Houtchens, Mark - Dock demo and Rebuild

Response to SHL21-038 Request for Information 1

RE: SHL21-038 Request for Information 1, 6024 SE 22nd St (Houtchens)

**PROPOSED OVER-WATER CALCULATIONS:**  
DOCK (TOTAL OVER-WATER FOOTPRINT) = 1094.2 SF  
TOTAL NET REDUCTION = 573 SF  
PROPOSED PILES OVER 8" = 20  
PROPOSED PILES UNDER 8" = 4  
PROPOSED NET REDUCTION IN PILES = 12

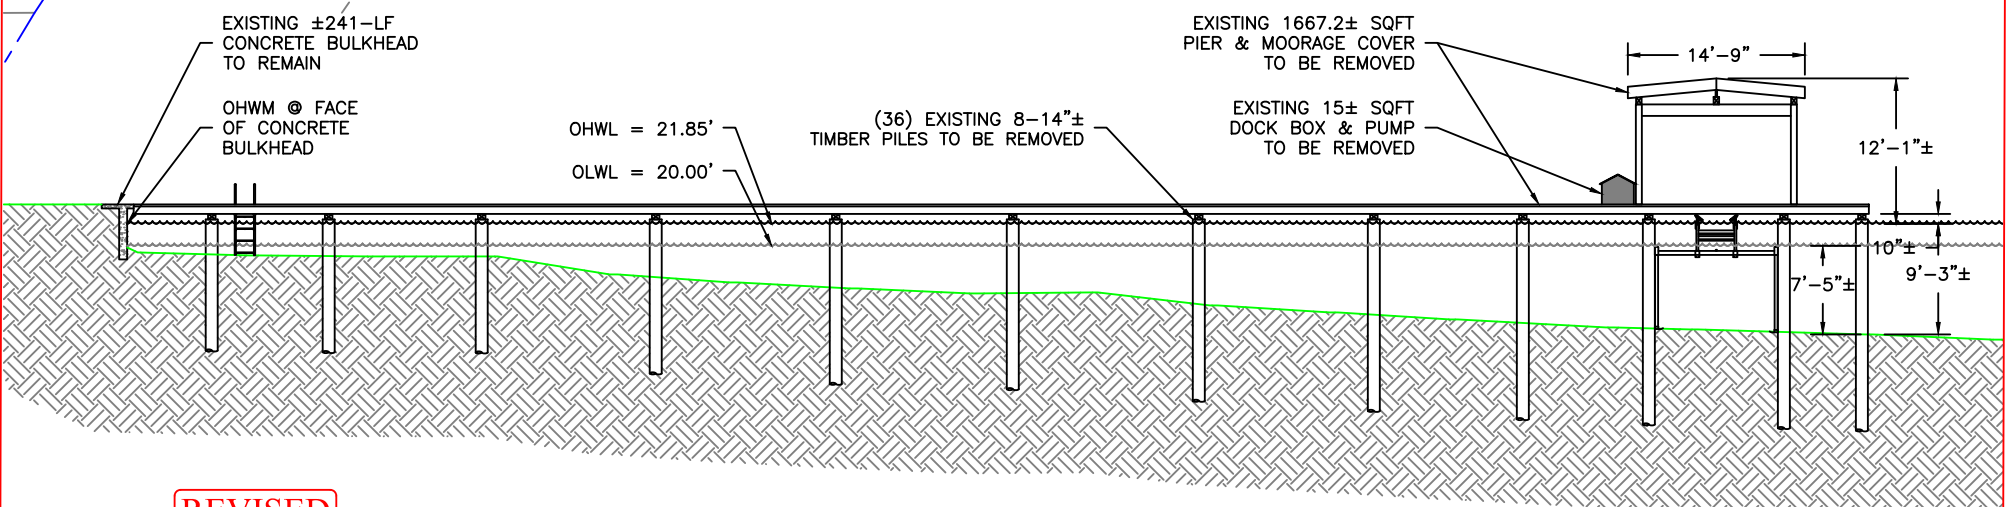
ii. The area, width, or length of the structure is not increased, but may be decreased;

[WCI: Proposed scope will reduce the overall footprint of the pier from 1416 s/f to 1094 s/f.](#)

**PROPOSED PLAN DETAIL VIEW**  
SCALE: 1/16"=1'

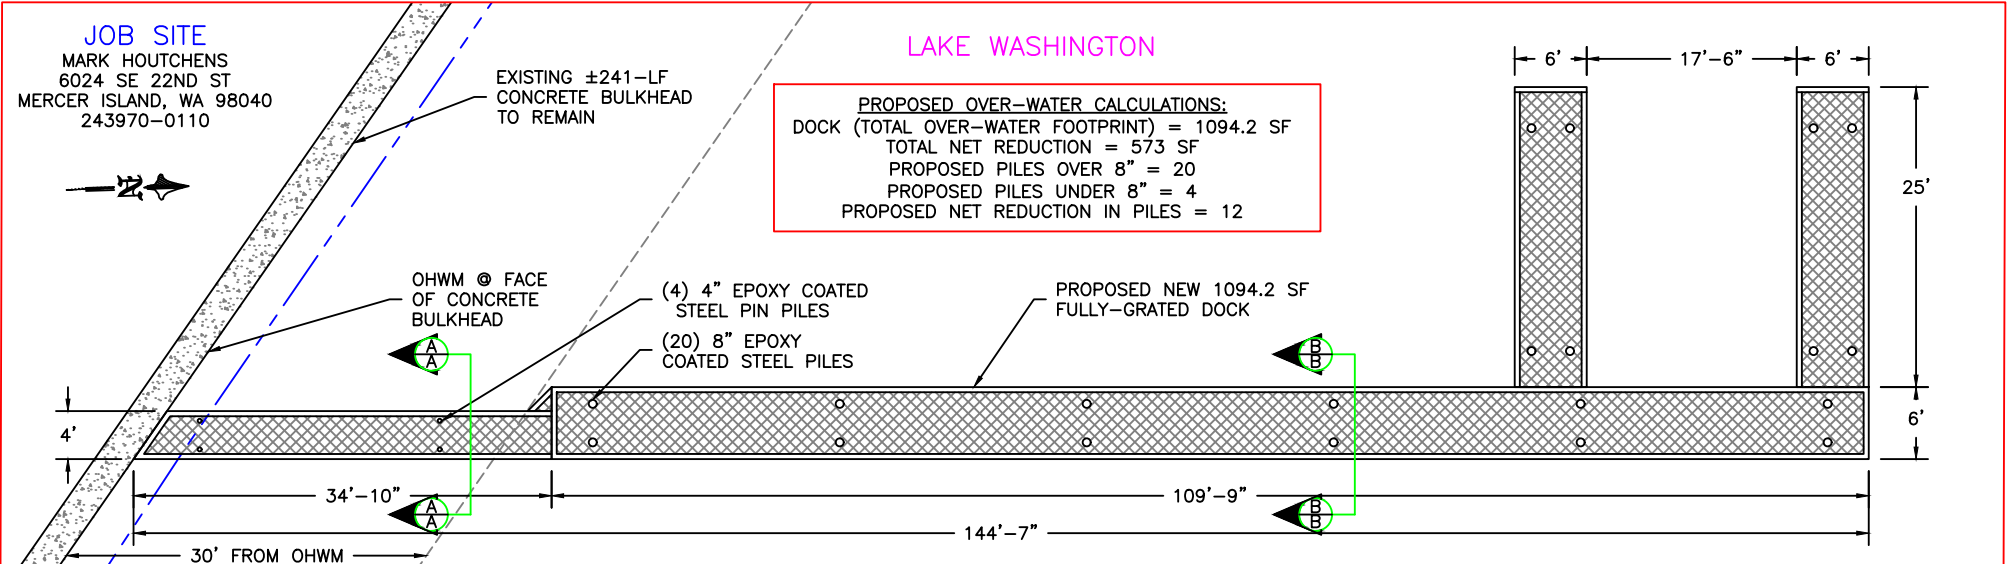
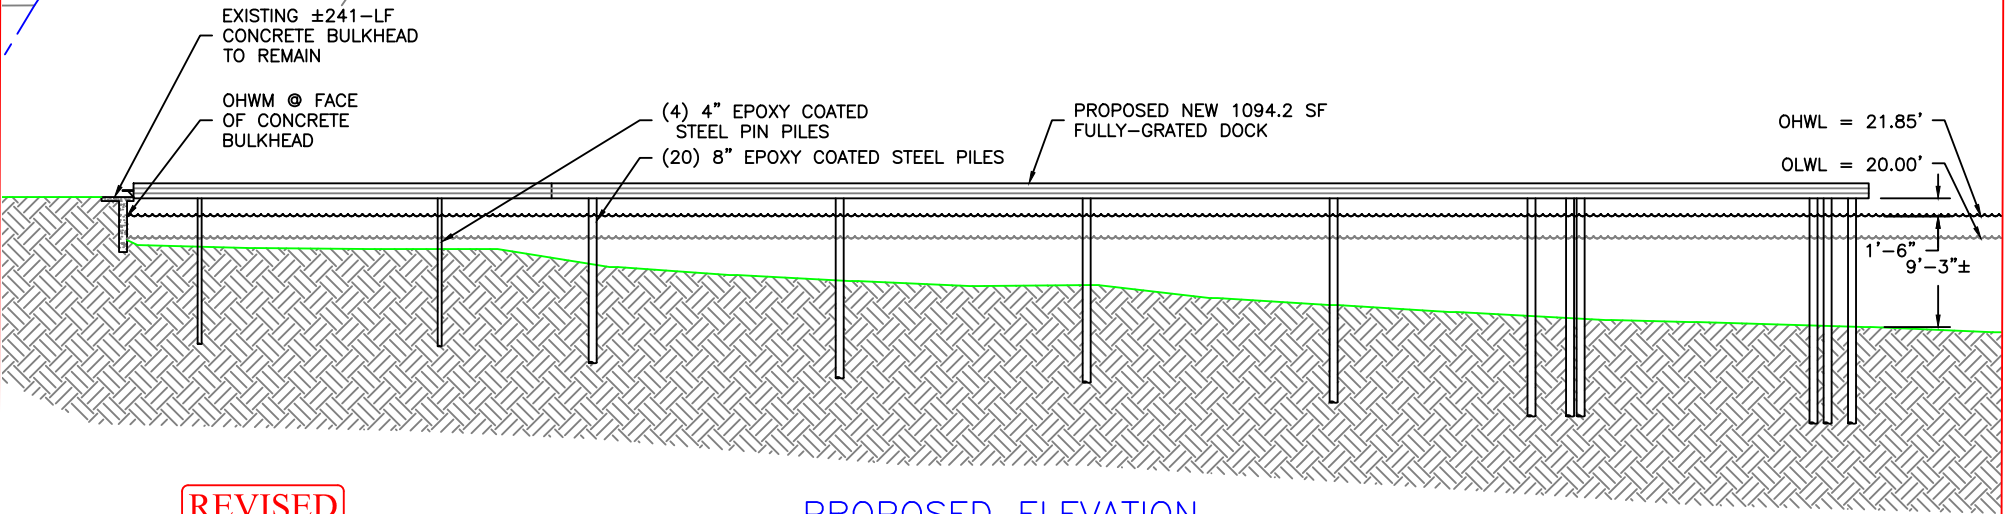
1. The entire dock is proposed to be reconstructed through this application. Due to the fact that more than 50% of the dock is being replaced, MICC 19.13.050 (F)(2)(ix) applies. MICC 19.13.050 (F)(2)(ix)(c) states that: An existing moorage facility that is five feet wide or more within 30 feet waterward from the OHWM shall be replaced or repaired with a moorage facility that complies with the width of moorage facilities standards specified in Table D of this section

Table D allows a maximum dock width of 6 feet wide on moorage facilities more than 30 feet waterward from the OHWM. The portion of the proposed dock that is 11'- 11" must be reduced to meet the 6 foot dock width requirement.

[WCI: A portion of the dock has been reduced to 6' wide, as described above. Please see Proposed Plan Detail and Elevation Views on page 5 of the attached plan set "HOUTCHENS-MARK - MIRBLD - A-PLANSET REVISED 12-22-2021".](#)

iii. The height of any structure is not increased, but may be decreased; provided, that the height above the OHWM may be increased as provided in subsection (F)(2)(ix)(b) of this section;

[WCI: Proposed scope will completely remove the existing 12'-1" tall moorage cover. Please see Proposed Plan Detail and Elevation Views on page 5 of the attached plan set "HOUTCHENS-MARK - MIRBLD - A-PLANSET REVISED 12-22-2021".](#)
